CITY OF ALBUQUERQUE

**Re: Las Lomas Plaza, Building 1 & 2, Phase 2
2101 & 2105 Vista Oeste NW
60-Day Temporary Certificate of Occupancy
Transportation Development Final Inspection**
Engineer's/Architect's Stamp dated 4-26-18 (H10D031)
Certification dated 12-12-18

Traffic Control Layout

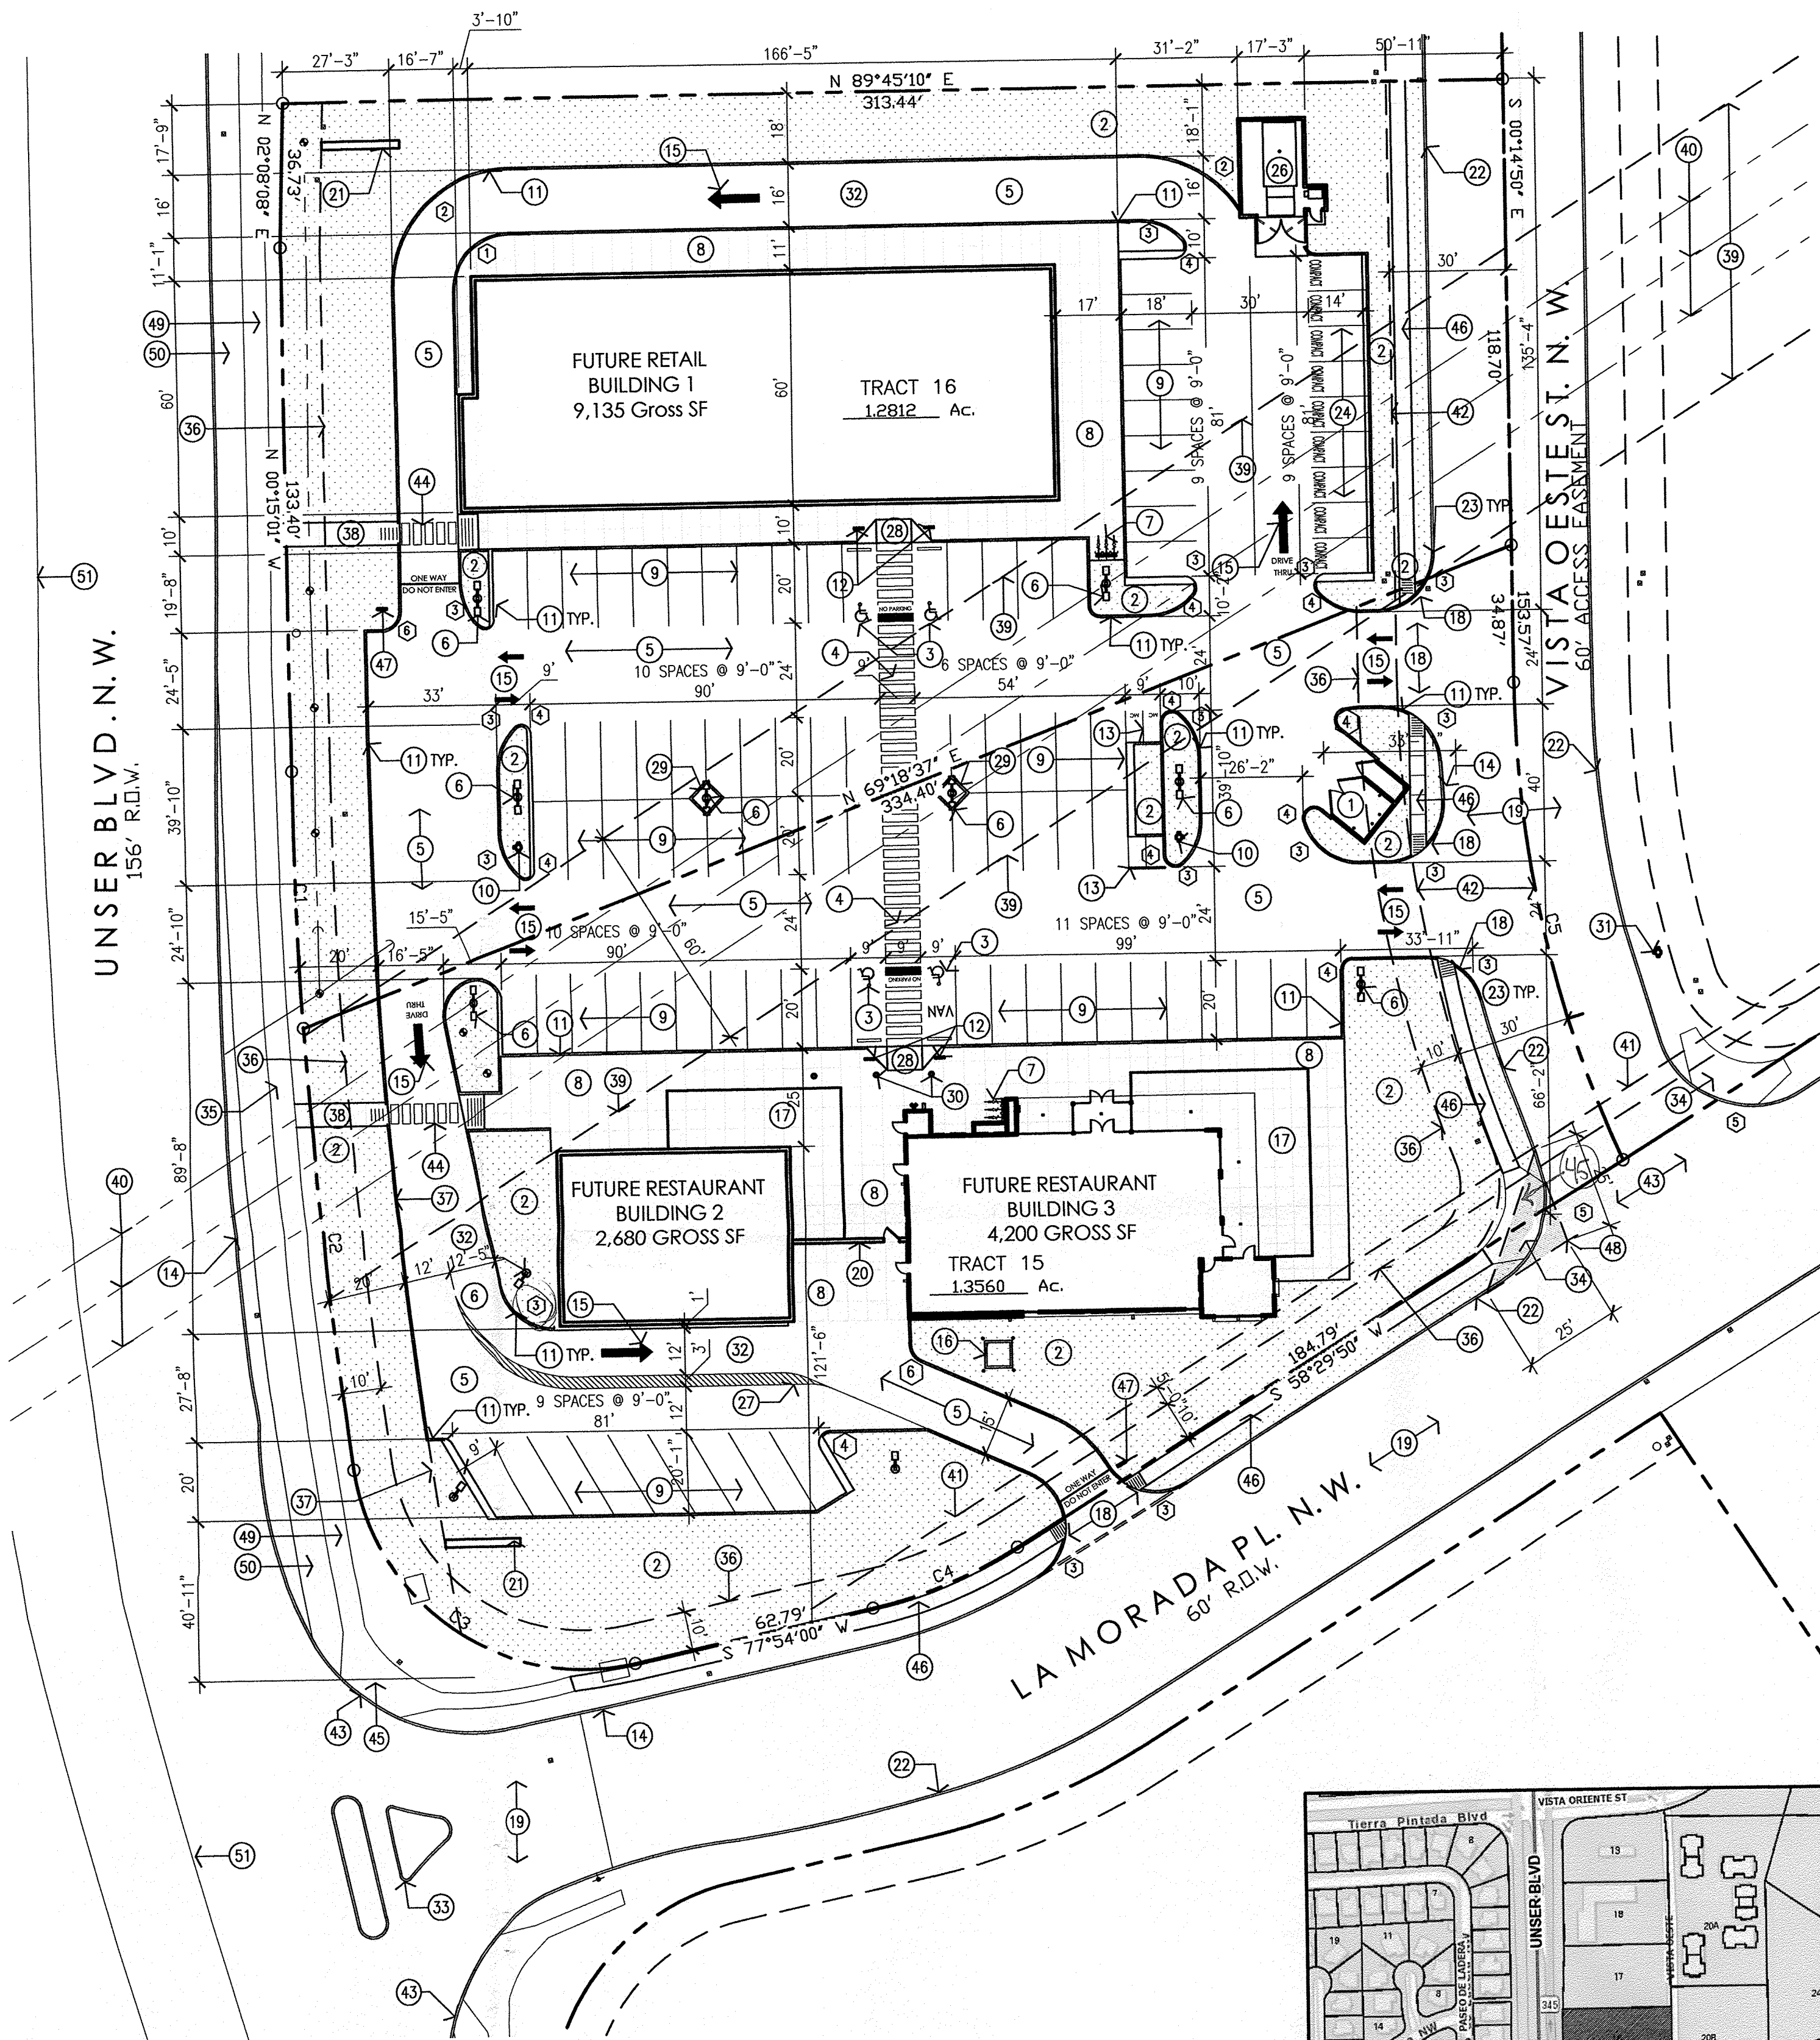
1. Please add bicycle parking, Building 1.
2. Please paint COMPACT on all parking stalls listed as compact on approved TCL plan.
3. Please add 6ft wide accessible pedestrian pathway from public sidewalk to building entrance for Building #1 off Unser. Because of steep slope stairs will be okay.
4. Photos of corrections will be sufficient when requesting final CO.
